Howerton Services, PLLC
License # P-1716
3513 Cathedral Bell Road
Raleigh, NC 27614
(919) 270-3460

Subject: 32 Dauphine Street
Fuquay Varina, NC 27526
Expanded Pier Footing Letter
Harnett County Permit #: SFD2308-0046

Based on the request of the Contractor, I inspected the modified pier footing for code compliance. My assessment and recommendations are as follows:

Crawl Space Foundation Plan

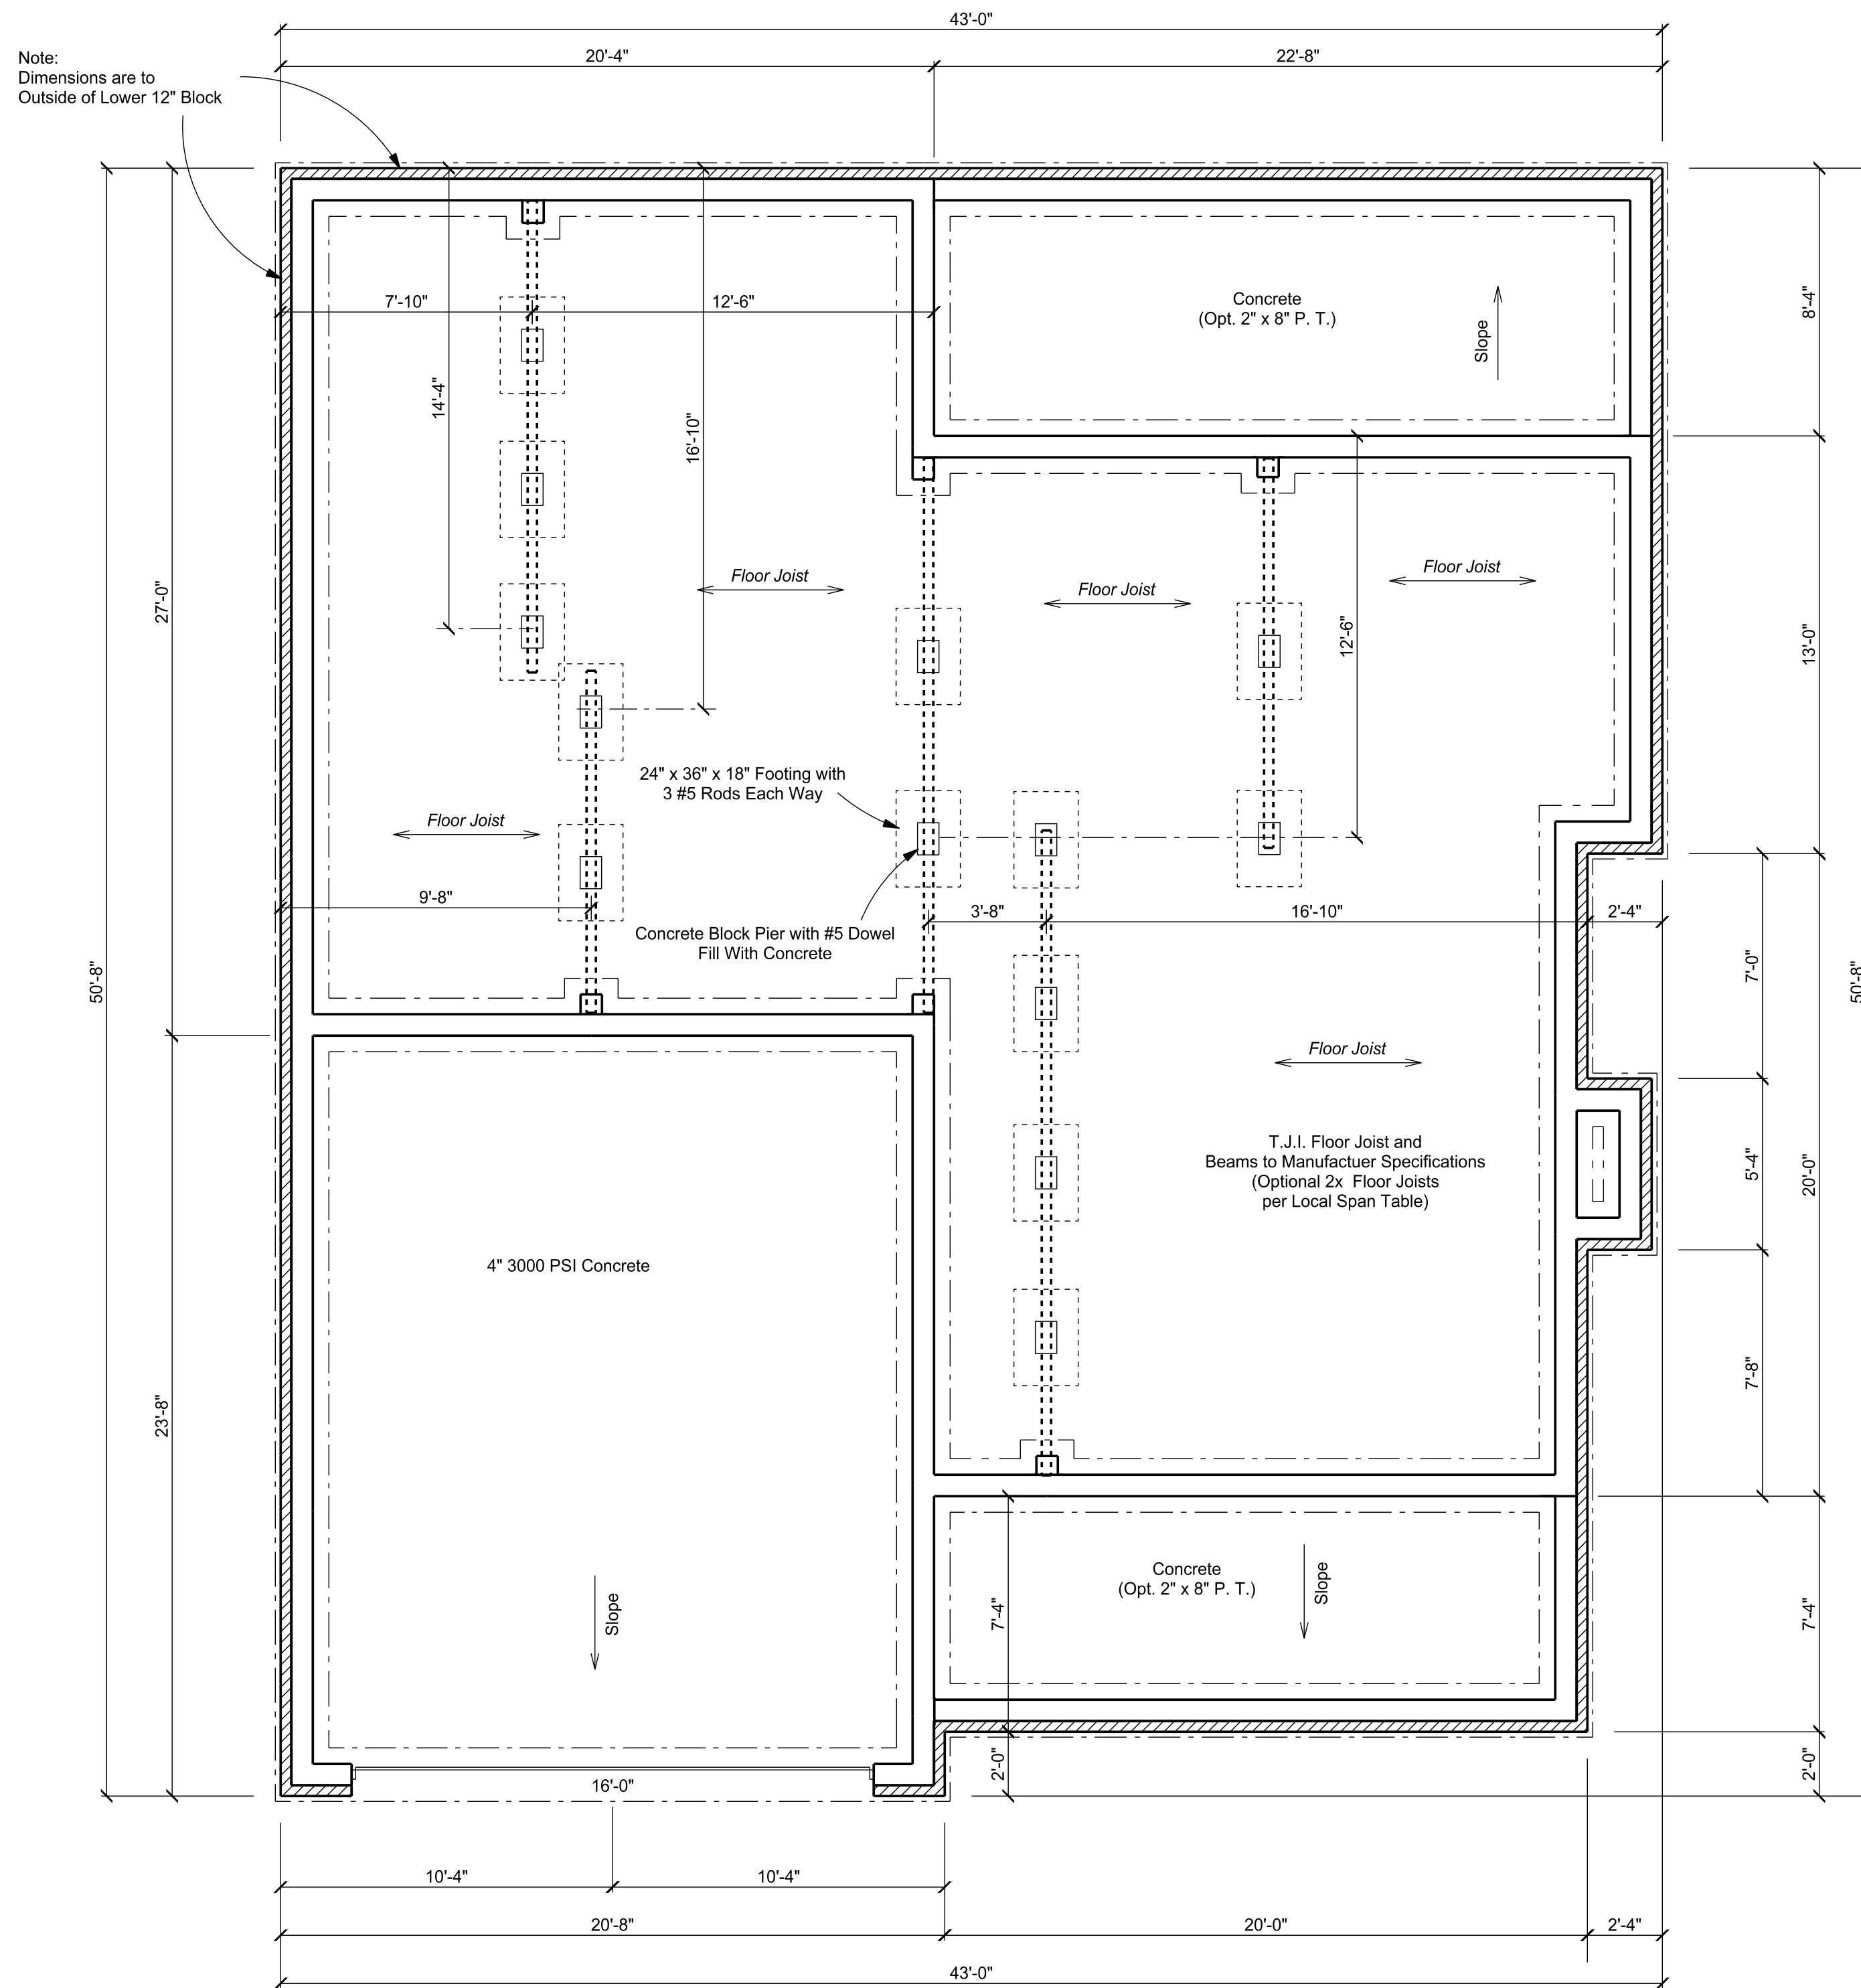
- The footing for 1 pier in the crawlspace was not excavated in the correct location. The masonry pier is too close to the edge and there is not proper footing projection for the pier. The Contractor excavated an additional 12" on the 1 side on the pier footing with the improper projection. The #4 dowel bars were added to the existing portion of the footing to tie the proposed footing to the existing footing. The new portion of the footing was excavated to the proper dimensions, and it has the proper density (2000 PSF). The Contractor has poured the concrete for the expanded footing. The expanded footing is acceptable.

The pier footing noted above meets all the requirements of the 2018 North Carolina Building Code for Residences.
